Planning Application Ref: R/272/18/T

Location: 1 St. Anthony's Way, Rustington, BN16 3EA

Description of works: Fell and remove 1 No. Beech tree & 1 No. Prunus Pissardii tree

PLAN OF TPO'S BEFORE PROPERTY WAS BUILT ON LAND

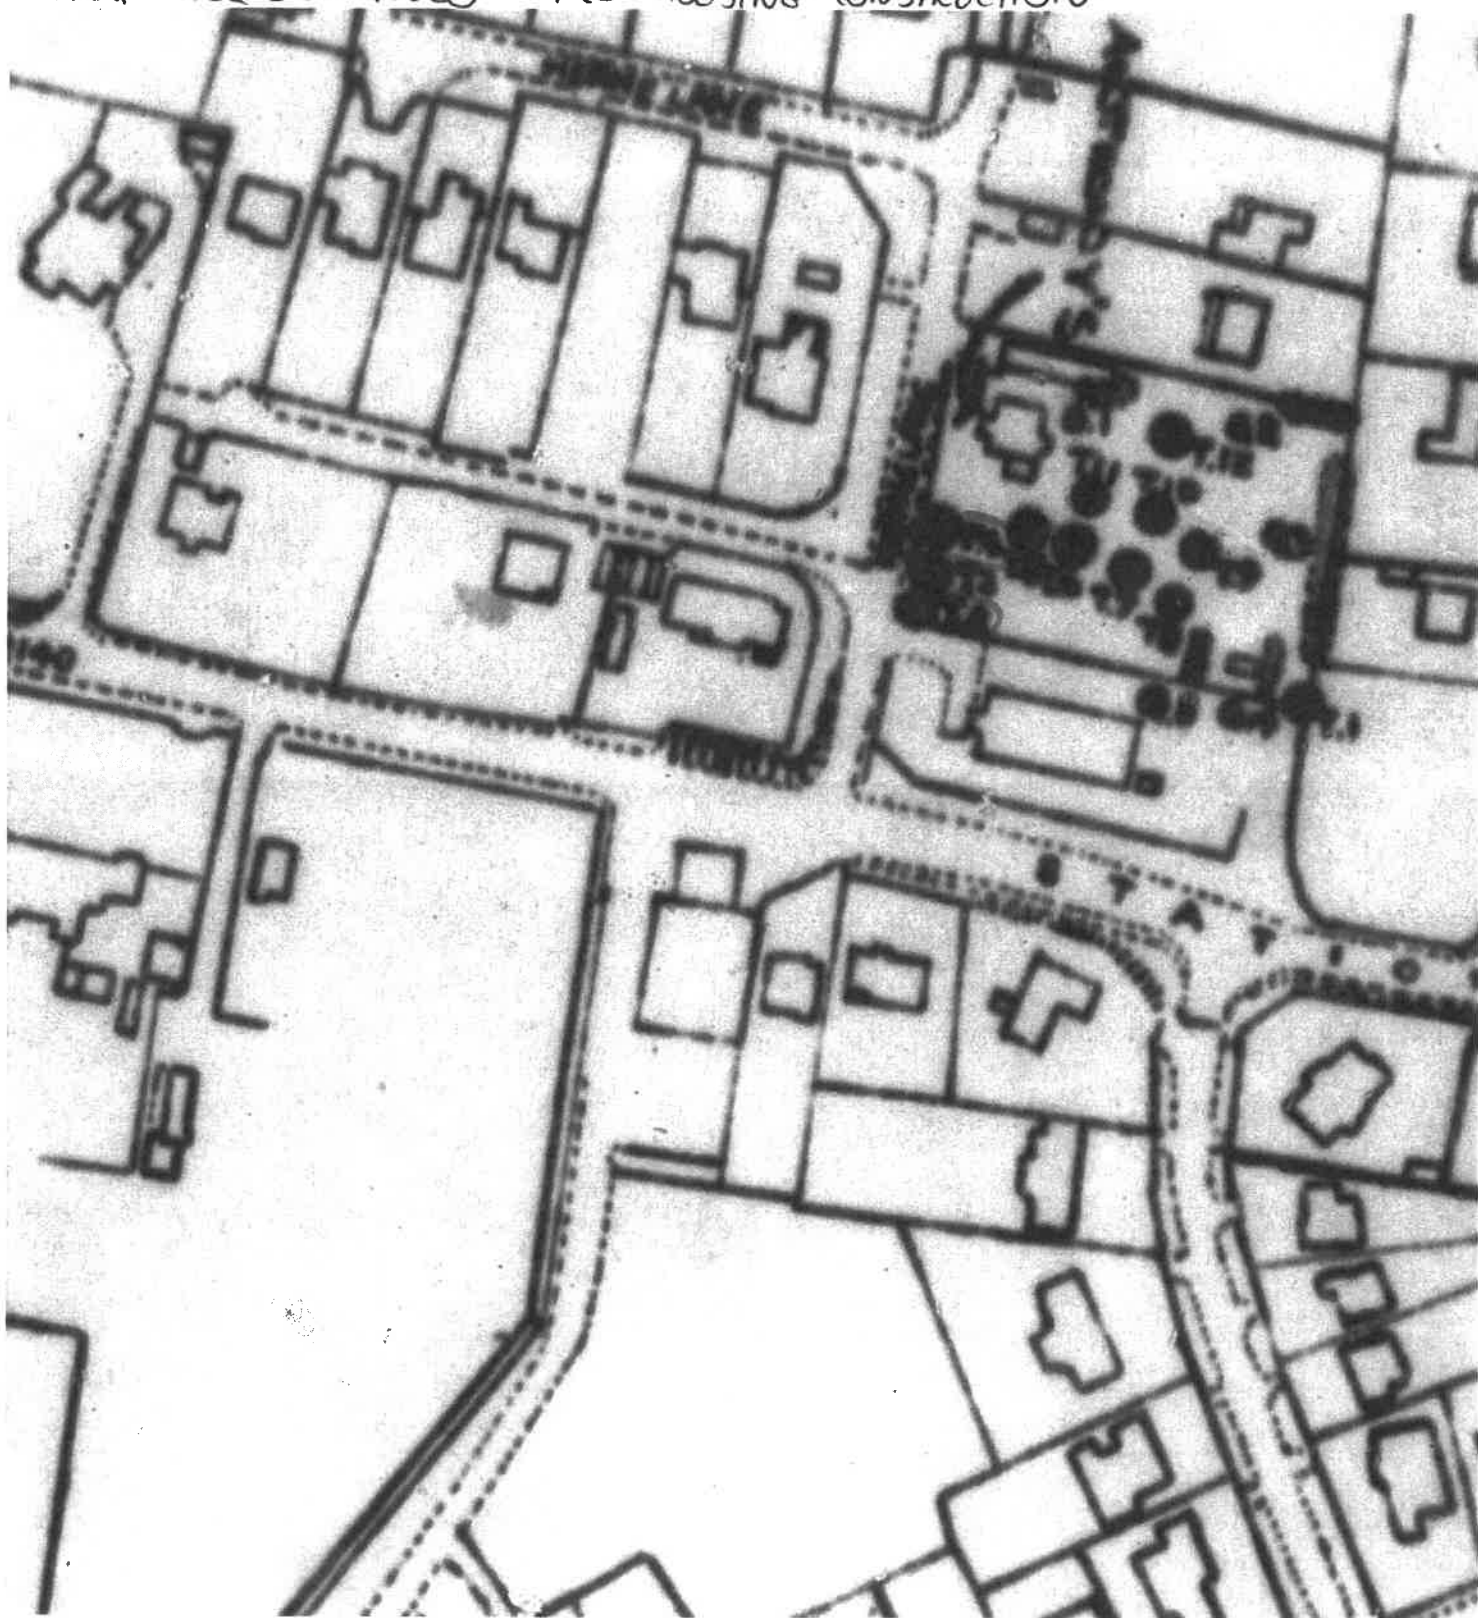
- T2 - Outwardly and from a distance it appears to be in a fair physiological state, although a large portion of the heavy main stem and surrounding ground conditions were not assessed. It has been the subject of extensive crown reduction and lifting operations which cumulatively have denied this tree adequate crown volume to sustain it. A number of branches are either dead or in decline. The form of this tree is such that while interesting by virtue of its size and historic landscape value - it provides little visual amenity to the surrounding area and is unlikely to ever present an attractive and tolerable crown profile.

- T4 – A small, established ornamental tree in apparent good health but only of moderate form, having been the subject of past crown reduction work. There is a significant decay fungi present at the main stem union, which although not investigated is likely to reduce the safe, useful life expectancy of the tree.

- The work proposed is justified on arboricultural grounds as both trees are compromised by the severity of past pruning work and/or ingress of significant decay.
- The beech tree is a significant feature in the local landscape and its loss will be of detriment to the visual amenities of the locality.

Once the tree (T4) has been felled (and either grubbed or ground out) then a replacement tree is to be planted in the same place or nearby and to within 2metres.

This is to be of Standard Nursery Stock proportions (10-12cm girth & 2m to 3m overall height) supported on a 'short stake' system with appropriate securing ties and pads.

It is to be planted within 12 months of the removal of the purple-leaved plum tree. The species shall be selected from the following:-
